**SSD-10396 – Proposed Kings Park Metal Recovery and Recycling Facility (RRF) expansion at 23-43 and 45 Tattersall Road, Kings Park**

# Blacktown City Council submission to SEARs request for SSD-10396

Figure 3 Available stacking spaces

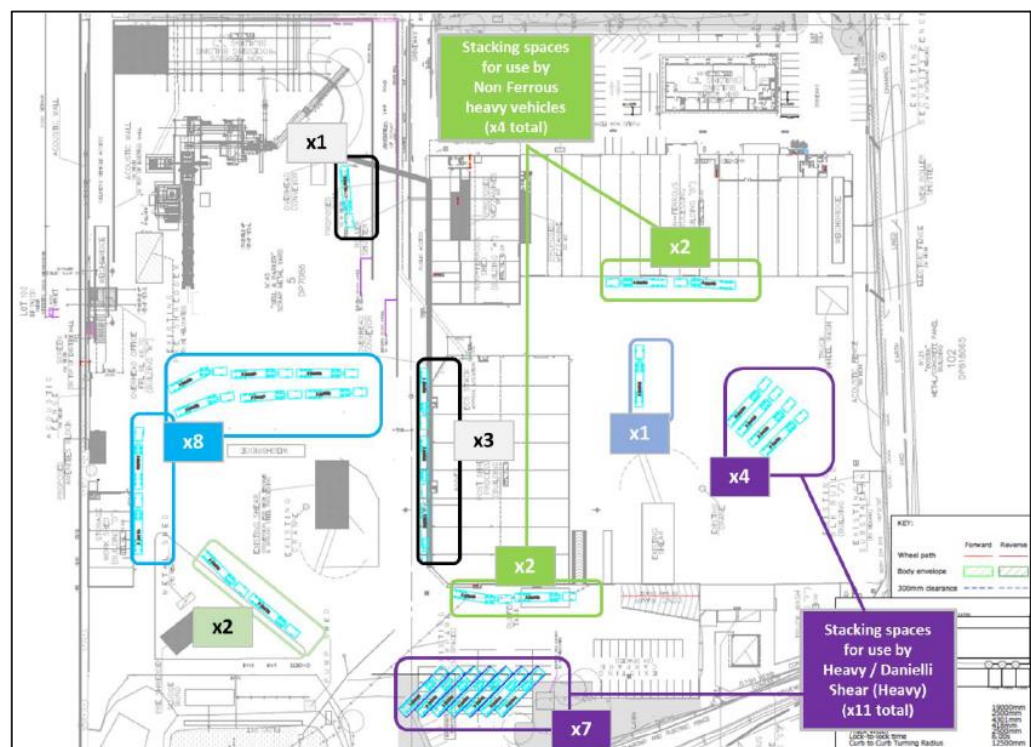
- b. In the current operation, there are already trucks parking on Tattersall Road as early as 6 am causing safety concerns. Considering that the proposed scrap metal throughput limit will be significantly increased, this on street truck parking and stacking problem is only going to get worse. This problem suggests that the road network and subject site cannot adequately cater for the current use, let alone a major expansion as proposed by this SSD application. The Applicant must advise how they are going to stop this problem continuing, and getting worse with the expansion, and the proposal cannot be supported until this issue is resolved.
